Date: 4 November 2014
Your reference: SSD 5300
Our reference: DOC14/259540
Contact: Calvin Houlison
4224 4179

RE: Kembla Grange Resource Recovery Centre EIS Exhibition (SSD 5300)

RUNOFF VOLUME FROM 1 IN 10_{YR}
ARI, 24 hr RAINFALL BURST

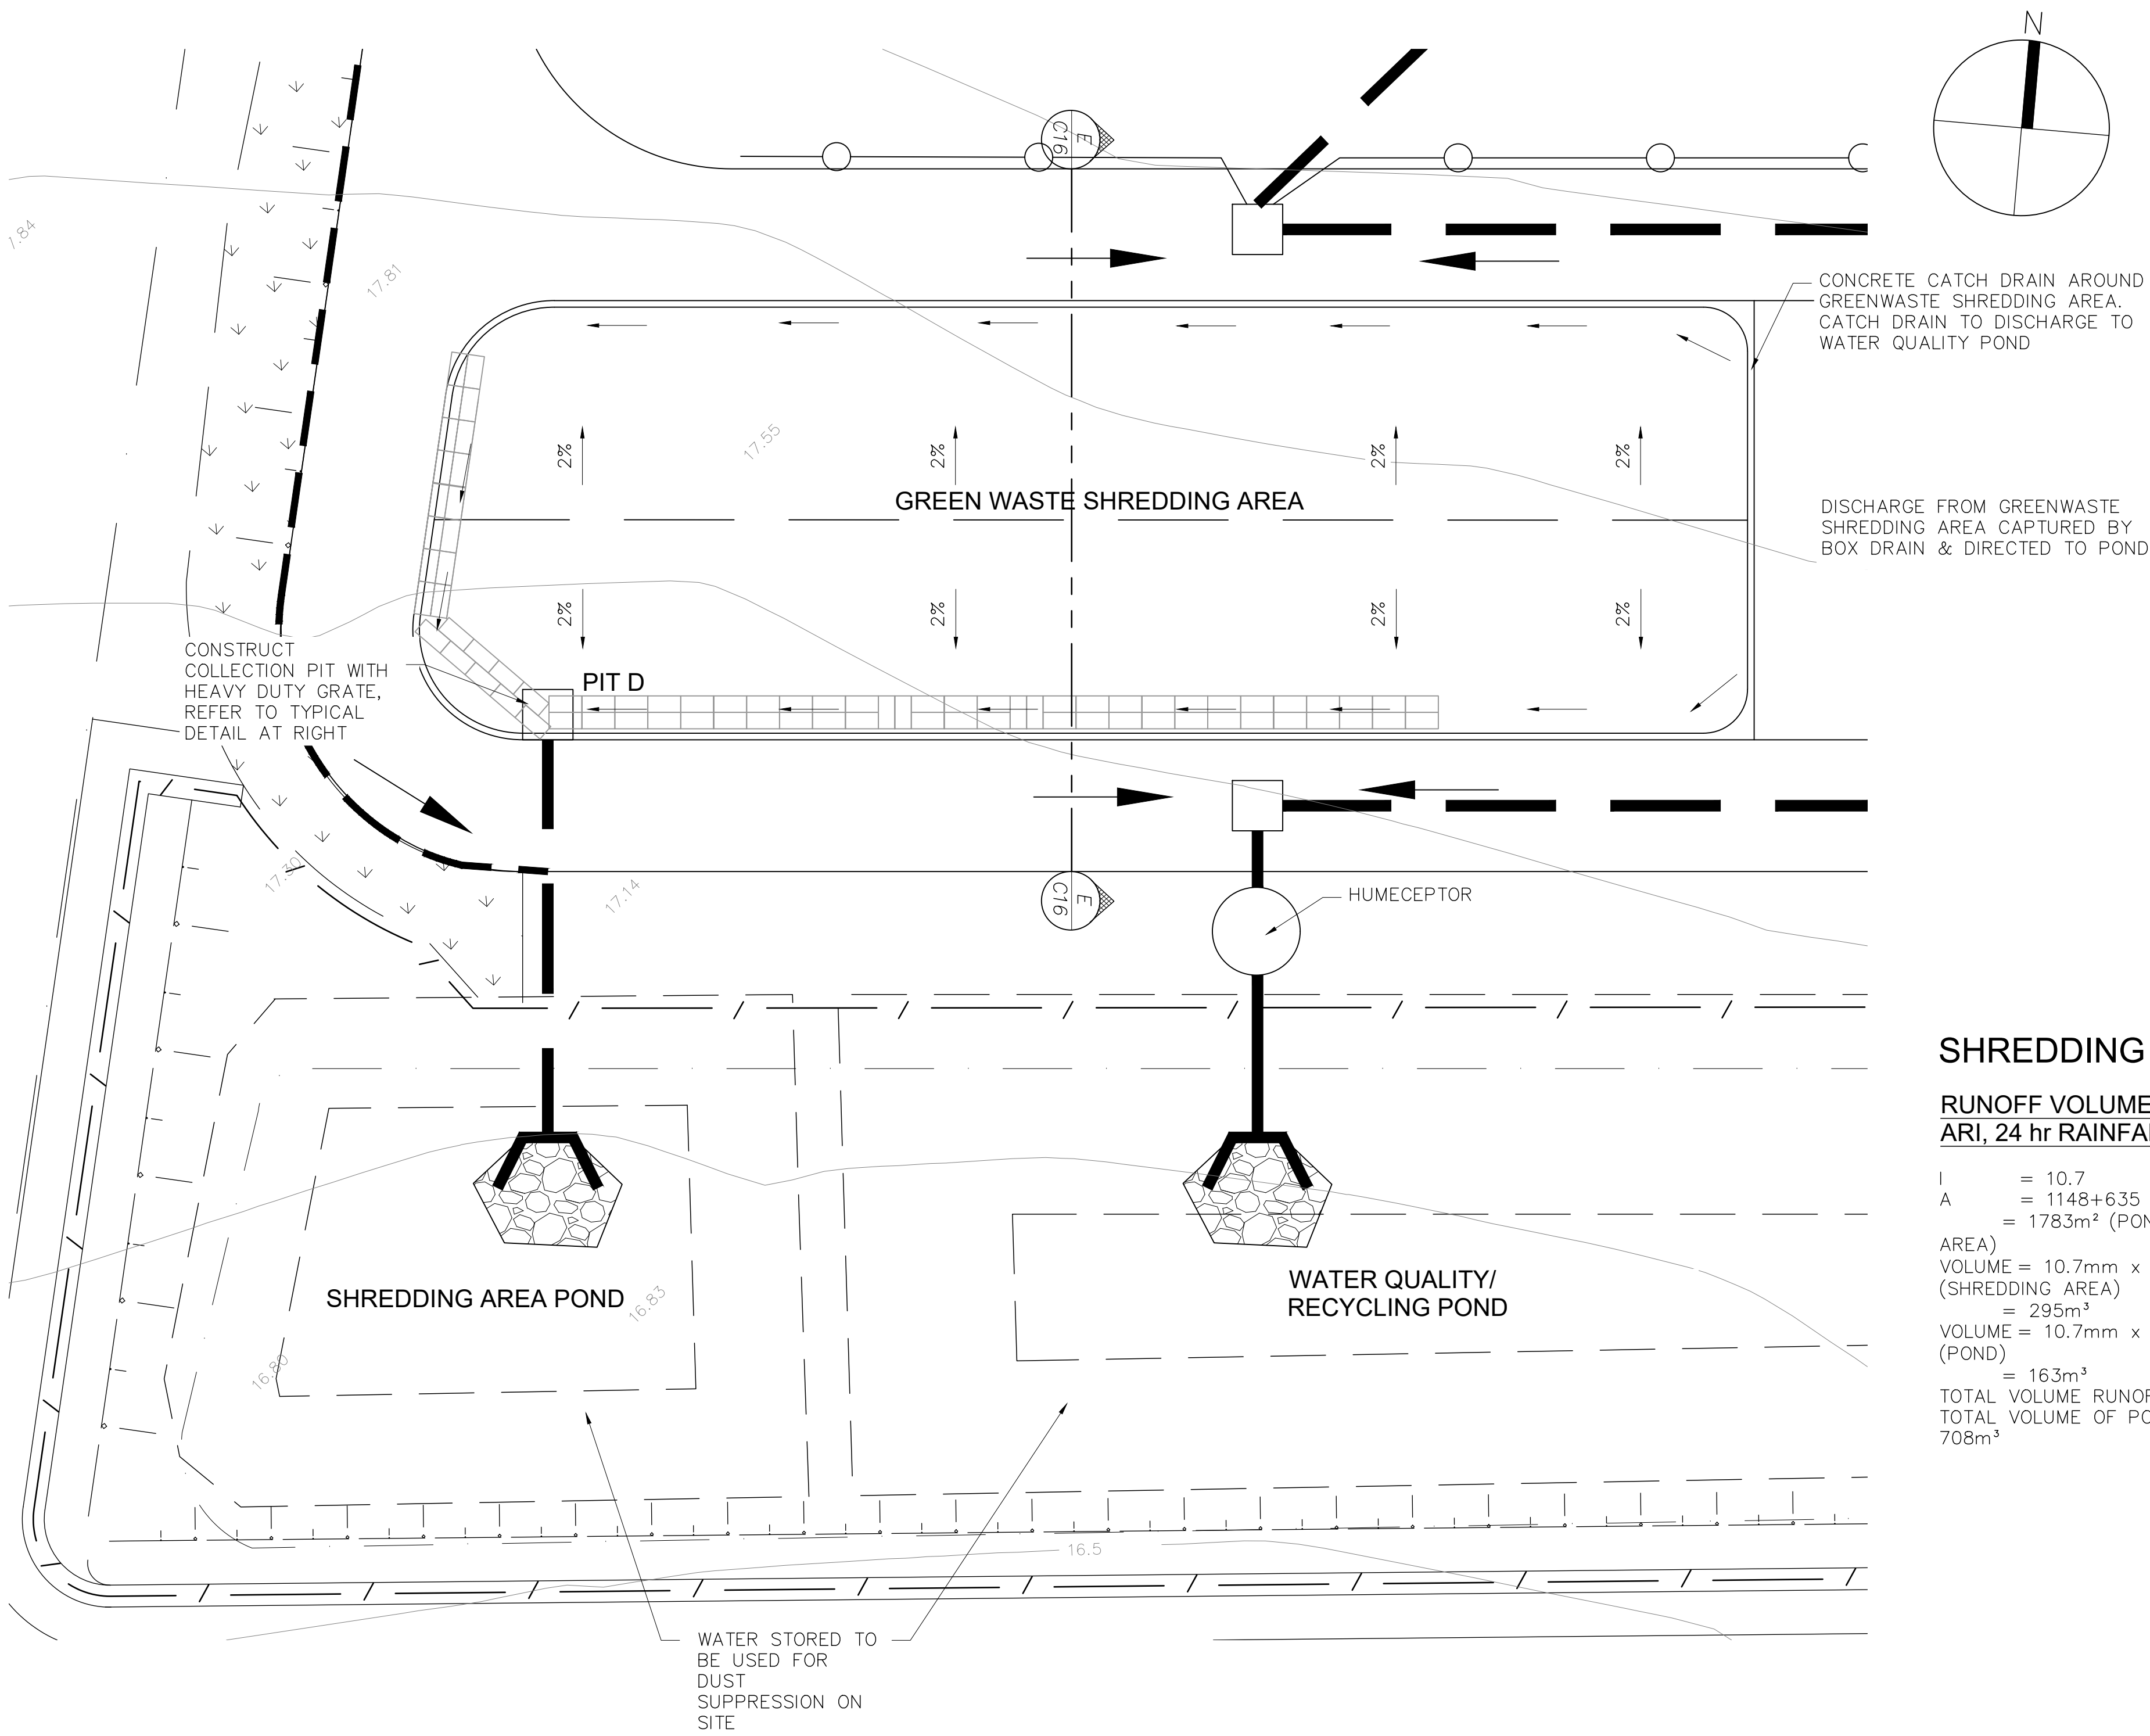
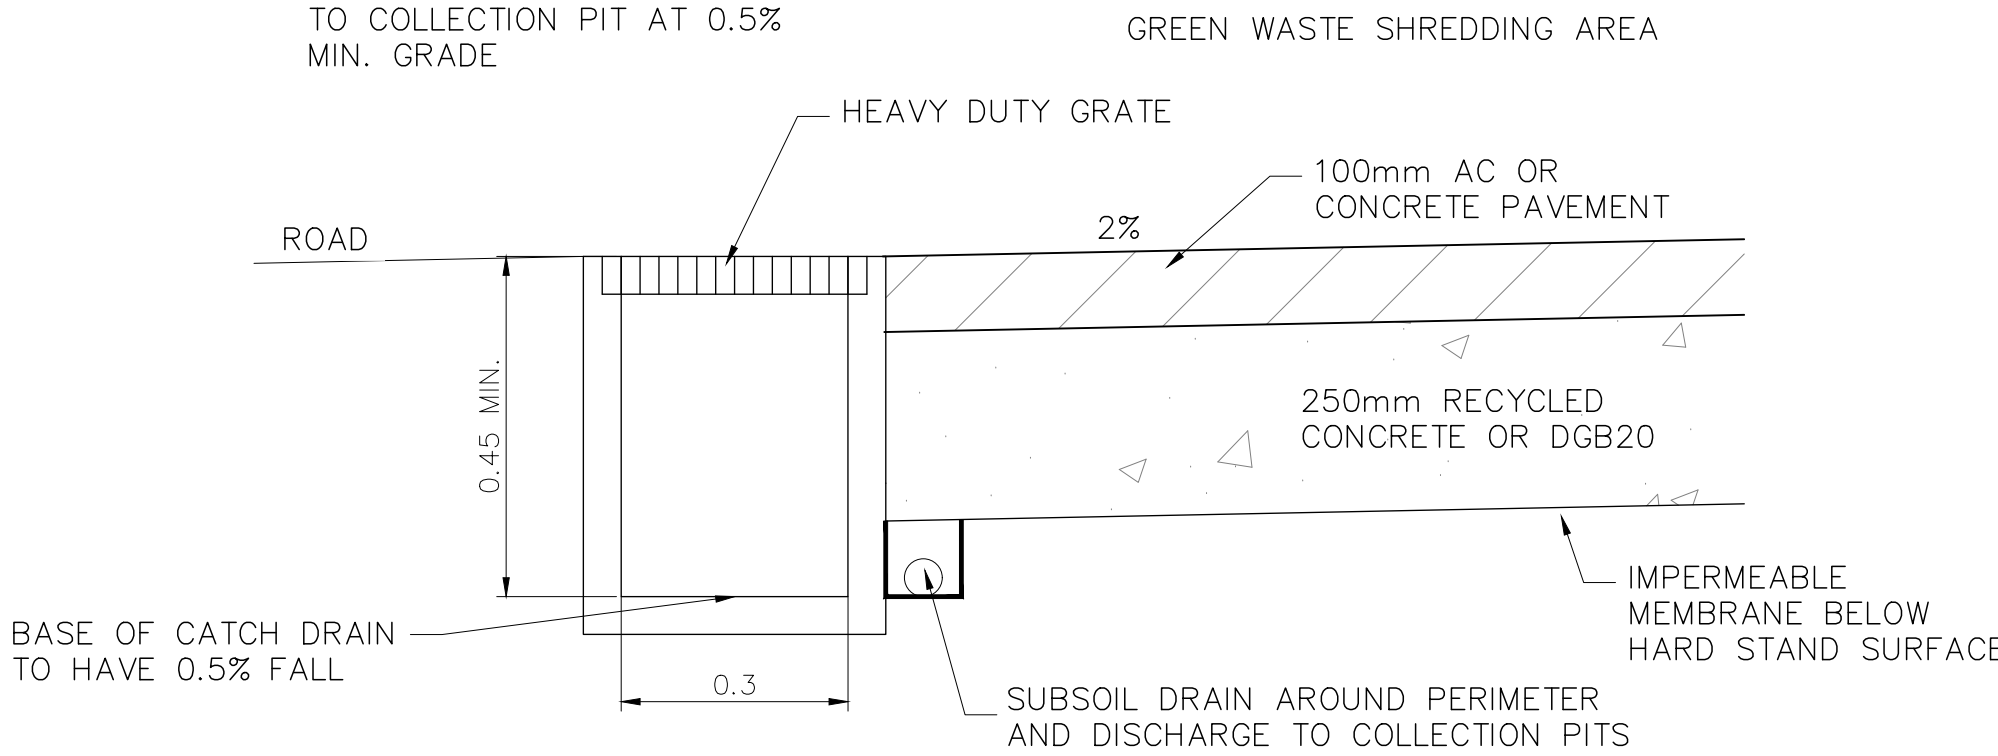
- DPE should be satisfied that the floodplain management and water quality matters raised previously have been addressed. This includes contingencies related to the performance of stormwater infrastructure to minimise impacts on Lake Illawarra sensitive receiving waters should design rainfall be exceeded. These include the shredding runoff pond, water recycling pond and detention basins A and B.
